CITY OF ALBUQUERQUE

December 13, 2019

RE: **Maverick at University & Menaul**
1901 Menaul NE
Grading Plan Stamp Date: 12/11/19 & 12/12/19
Drainage Report Stamp Date: 12/11/19
Hydrology File: H15D068

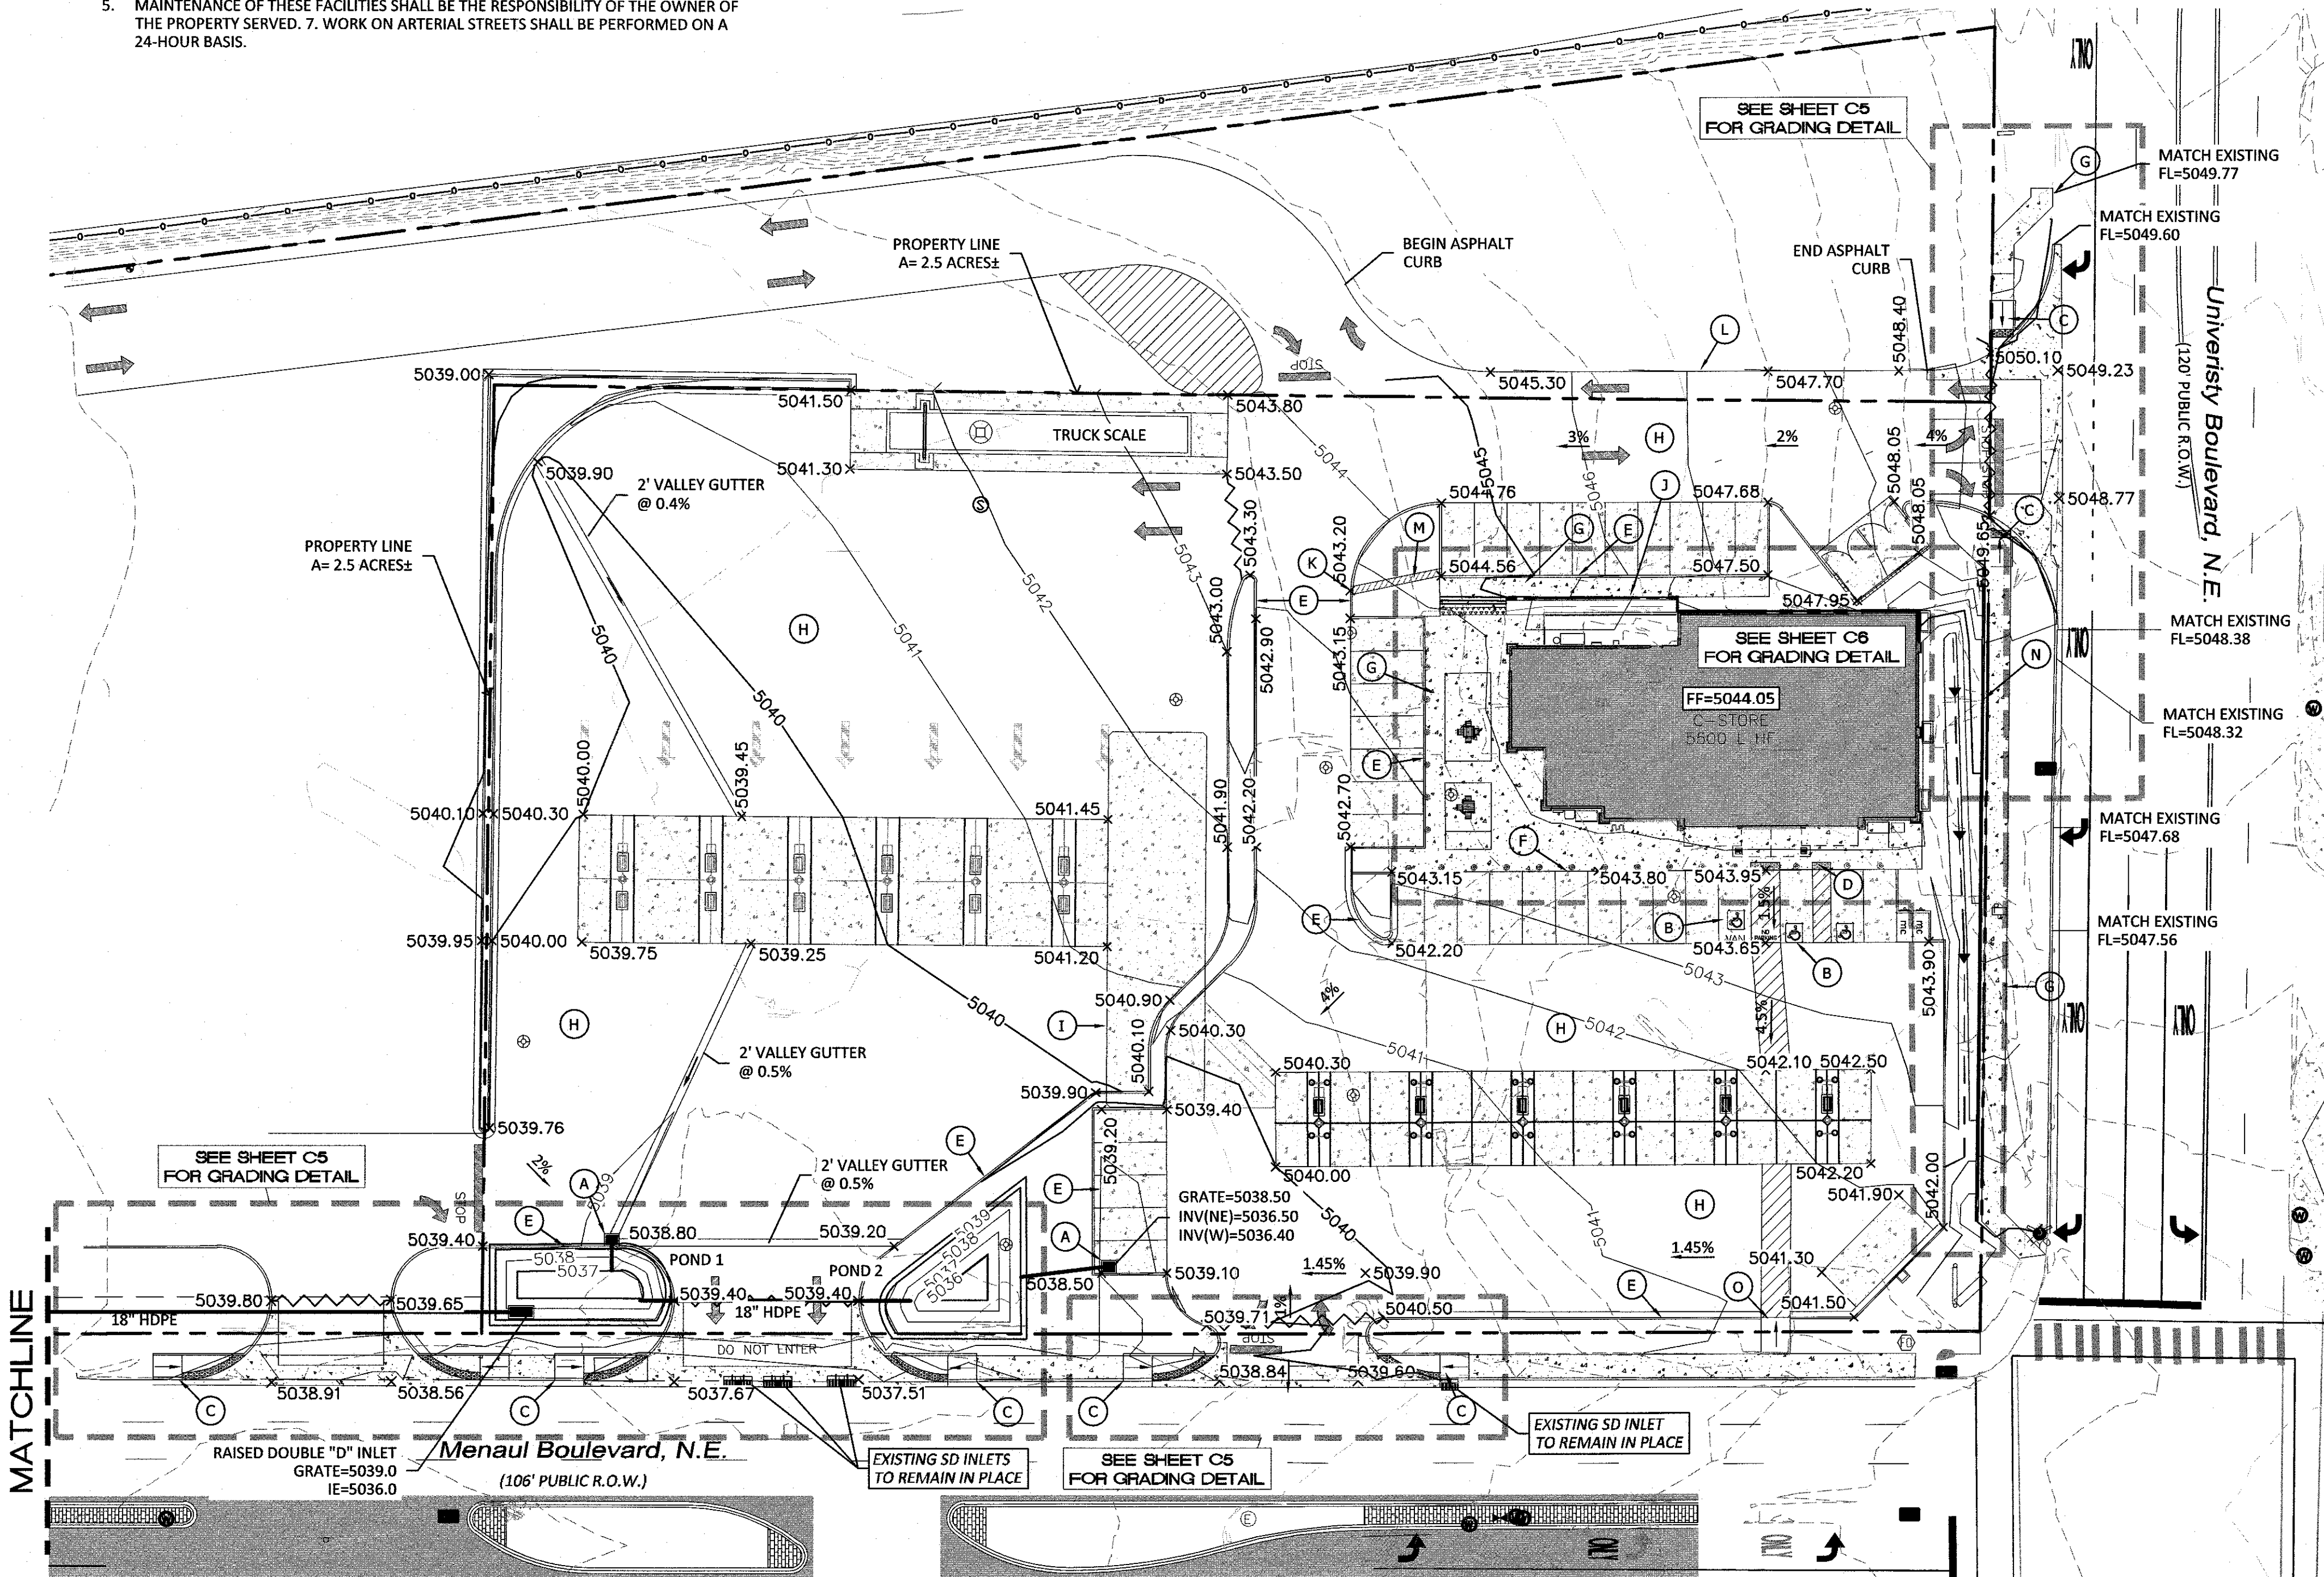
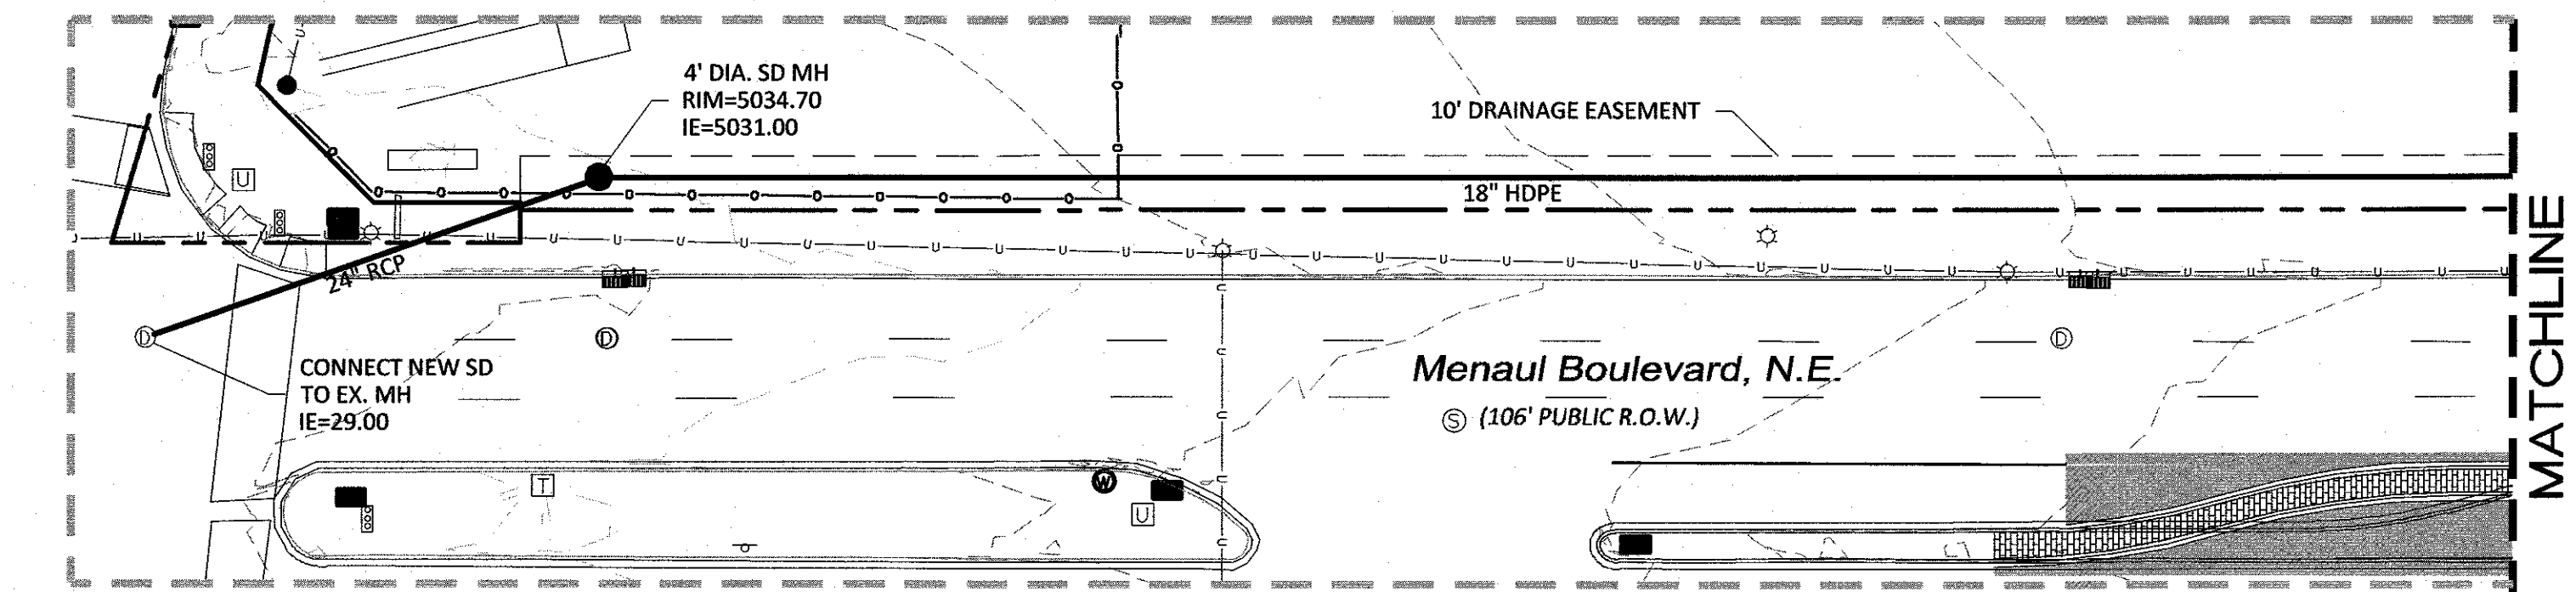
1. Provide a Revocable Permit and Slope Easement (measured at a 3:1 slope from top of wall to bottom of wall) for the retaining wall encroaching on University. Final recorded documents can be provided at CO, but they need to be initiated now. Turn in the documents to DRC on the 4th Floor for routing and then provide a copy along with a DTIS sheet when resubmitting for building permit approval. There is no resubmittal fee for this action; please include a copy of this letter when resubmitting to receive the reduced fee.
